23rd November 2017

Ref – Planning Application R/219/17/PL for the Erection of 1 No. dwelling (resubmission following R/64/17/PL) at St Mary's Close, Hurst Road.

Project: LAND AT ST MARY'S CLOSE, HURST ROAD, EAST PRESTON
Drawing Title: SINGLE DWELLING FLOOR PLANS

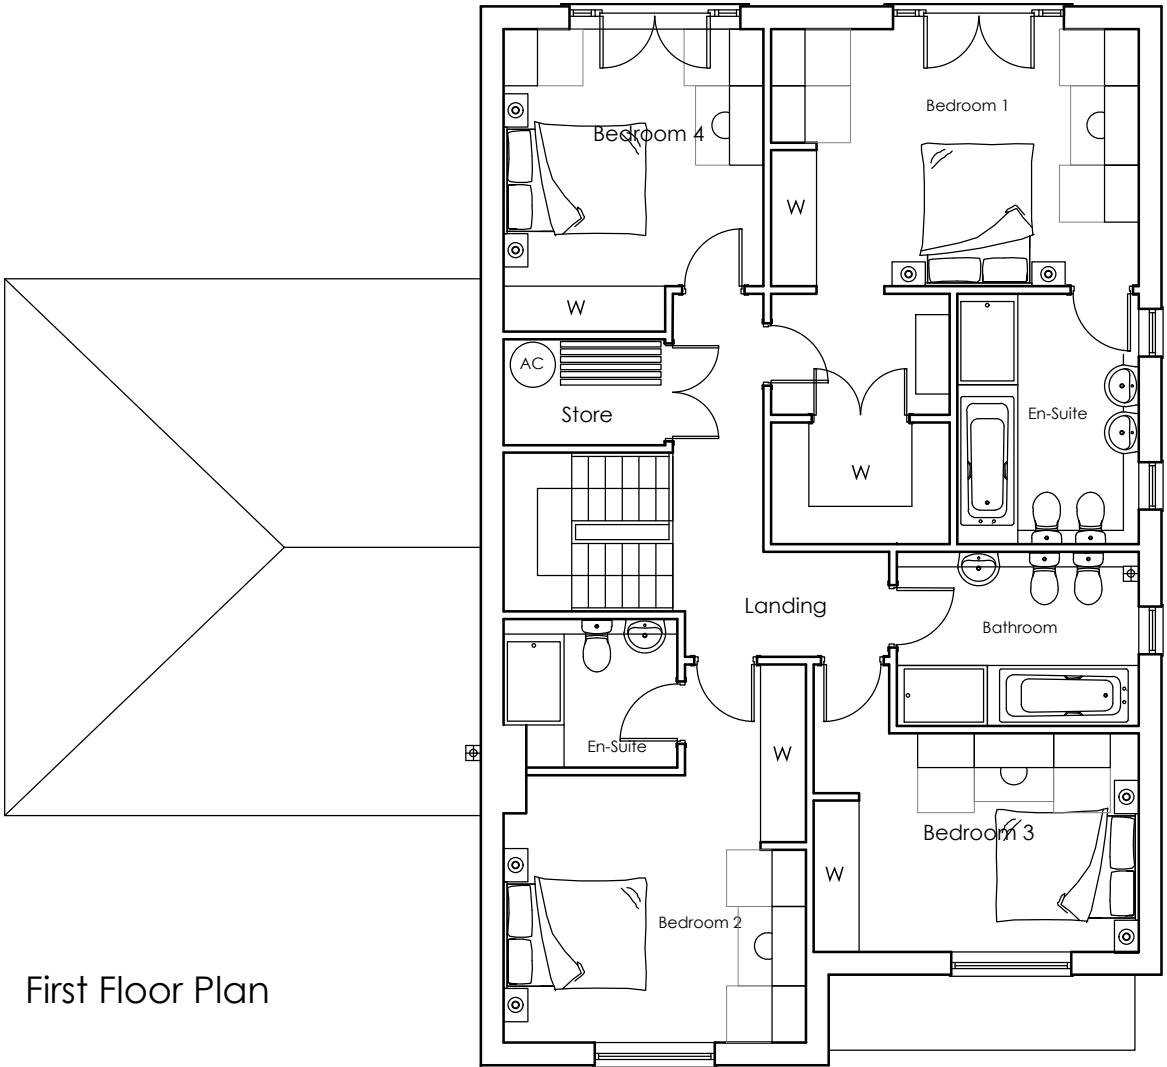
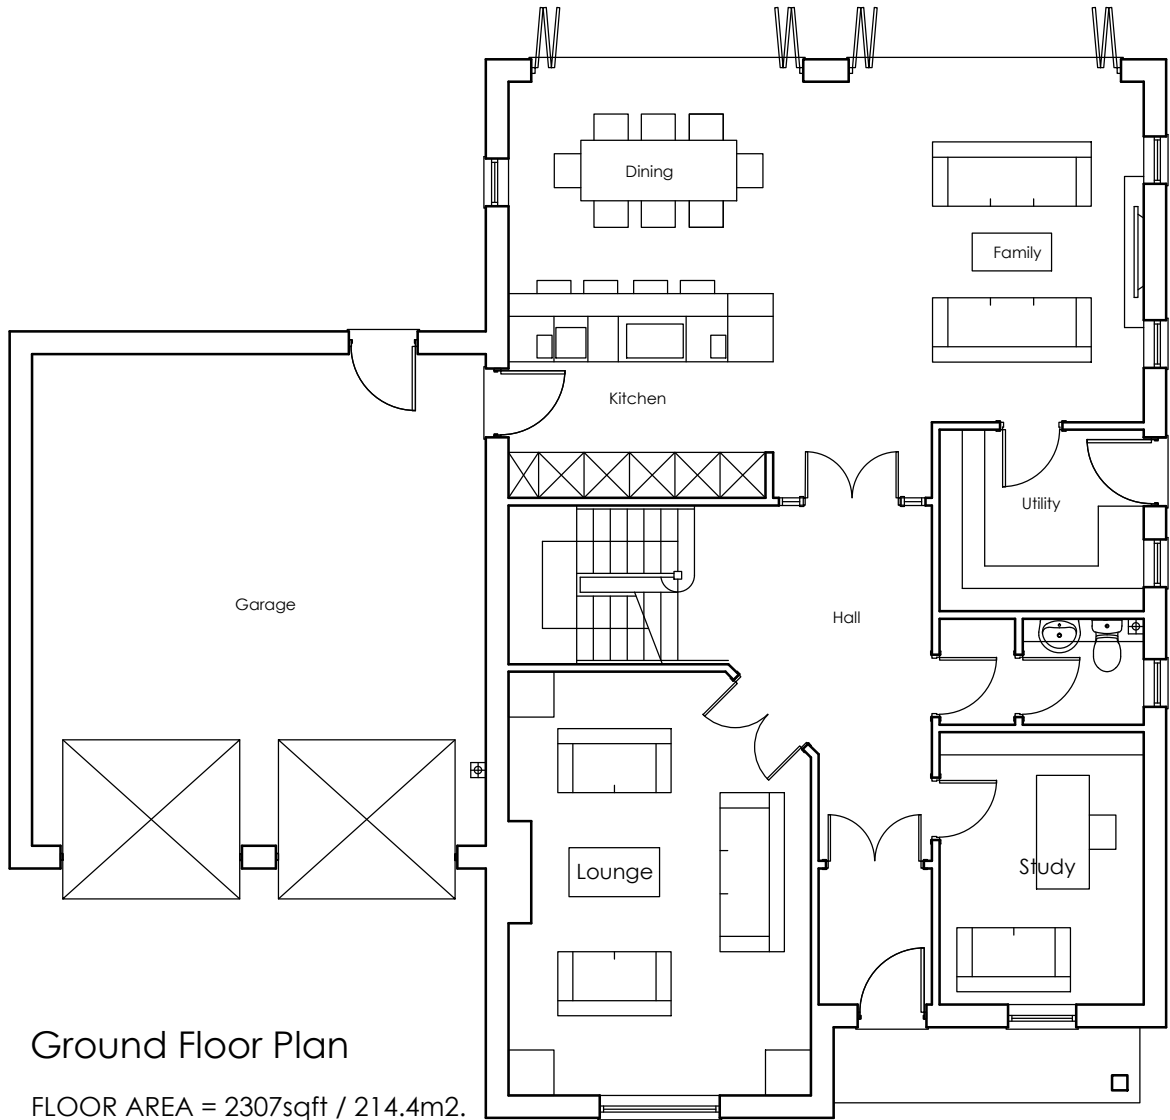
There are seven windows proposed on the western elevation, facing St. Marys Close. Some of these will be frosted for bathrooms but others will be clear glass which will overlook St. Mary's Close and seem excessive. For example, the family area has two large rear folding doors so are two additional windows really necessary on the western elevation?
